From: Hodgkiss, Christine [<mailto:christine.hodgkiss@veolia.com>]
Sent: Tuesday, 26 July 2016 6:29 PM
To: Fiona Gibson <fiona.gibson@planning.nsw.gov.au>
Subject: Re: RE: Randwick Council s96 submission

Further to our phone conversation today, please see below some clarifications on the proposed modification for the Banksmeadow Transfer Terminal (SSD 5855 MOD1) regarding right hand turn restrictions into the site and waste transportation requirements.

Banksmeadow Transfer Terminal SSD5855 Mod 1
Response to Submissions
July 2016

FIGURE 3B

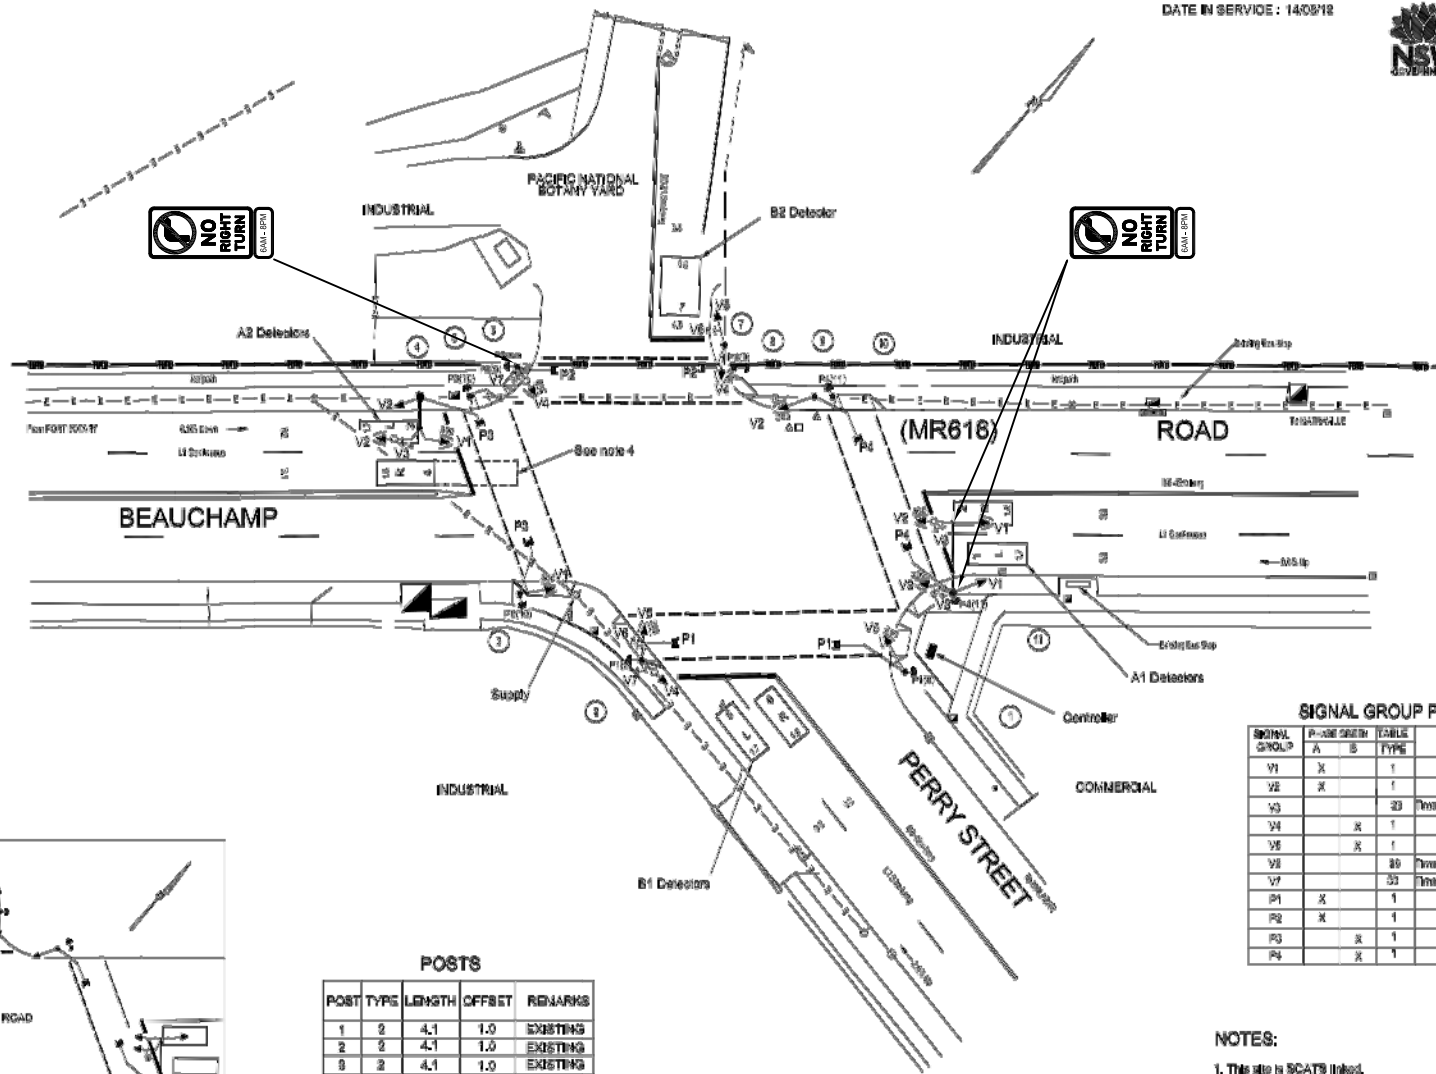
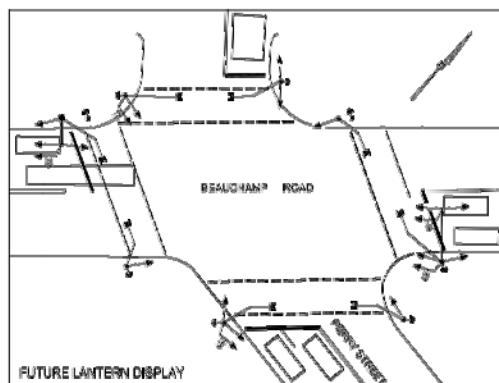
As required under Condition 24, Veolia submitted plans to RMS for review and endorsement in November 2015. As part of this review process, RMS initially requested a total right hand turn ban into the site, however through the review process, RMS advised that their primary concern was right hand turns during the daytime. As a result of this concern, RMS advised that a revised right hand turn ban from 6am to 8pm would be acceptable to RMS (refer to item 22 in the attached design review table & email from RMS dated 20 May 2016).

Authority	Comment	Veolia Response
RMS		
	Roads and Maritime has reviewed the submitted information and raises no objection to the proposed modifications to Condition 23 subject to the following condition is incorporated into the consent issued by the Department: 23B. Works Authorisation Deed (WAD) with Roads and Maritime for the works must be executed prior to the commencement of operations.	Veolia accepts the condition as drafted by RMS. It is noted that the terms of the WAD have been agreed between Veolia and RMS, and it is expected to be executed in the week commencing 18 July 2016.
Randwick City Council		
	In order to better control the possibility of trucks entering Perry Street, we would require that the road out of the Veolia site be adjusted so that the left lane have a "Left Turn Only" arrow marked upon the roadway (as currently proposed) and that the right lane have a "Right Turn Only" arrow marked upon the roadway. Also, the signals are required to be altered so that truck drivers instead of seeing a full green signal as they leave the site, they see only a left green arrow and a right green arrow. This adjustment will more effectively prevent trucks from going straight ahead into Perry Street.	The traffic signal operation including the signal lanterns and road marking in the intersection are the responsibility of the RMS. On this basis, Veolia forwarded Council's comment on to RMS and an extract of their response is provided below: "RMS being responsible for the operation of the signals do not have any objections to heavy vehicles travelling straight ahead into Perry St." The banning of heavy vehicles using Perry Street was requested by Council during the assessment process, and agreed to by Veolia. Condition 28(e) of the Development Consent states that "heavy vehicles do not use Perry Street to travel to/from the site". This commitment is not affected by the proposed modification and Veolia has already incorporated controls measures for the operations to manage this requirement. Traffic restrictions have been included in the site safety requirements and a CCTV system has been installed on site that enables monitoring of trucks travelling to and from the site to ensure that waste trucks are not utilising Perry Street. It should be noted that this access also provides vehicular access to the remaining portion of Asciano's land and this land is not subject to Veolia's consent, so if Asciano requires access to their land, they are permitted to use Perry Street and therefore the signal operation needs to cater for this. In addition, the turning movements out of the site are filter turns and therefore cannot be signalised with arrows under the approved traffic signal phasing.

Also, Randwick Council has strong concerns that the extension of the No Right Turn hours into the site, so that they apply from 6am – 8pm, is likely to encourage more trucks into Perry Street. This is because truck drivers approaching the site from the north will, once they drive past the site, be strongly motivated (time /money) to turn left into Botany Road, left into McCauley Street and then left into Perry Street in order to access the site as efficiently as possible. And, if they do approach from the north, there is no other alternate 'turn around' area for the drivers to come back northbound to the site. Allowing the right turn through the inter-peak part of day will reduce the likelihood of truck infiltration into the, more sensitive, residential areas.	The extension to the no right turn hours from Perry Street into the site was required by the RMS as part of the detailed design approval process for the intersection upgrade works. As noted above, Condition 28(e) of the Development Consent states that "heavy vehicles do not use Perry Street to travel to/from the site" and the proposed modification does not seek to change this requirement. Traffic restrictions have been included in the site safety requirements and a CCTV system has been installed on site that enables monitoring of trucks travelling to and from the site to ensure that waste trucks are not utilising Perry Street.

"a right turn restriction into the site from Beauchamp Road shall be implemented between 6am – ~~10am~~ and 3pm – ~~7pm~~ 8pm".
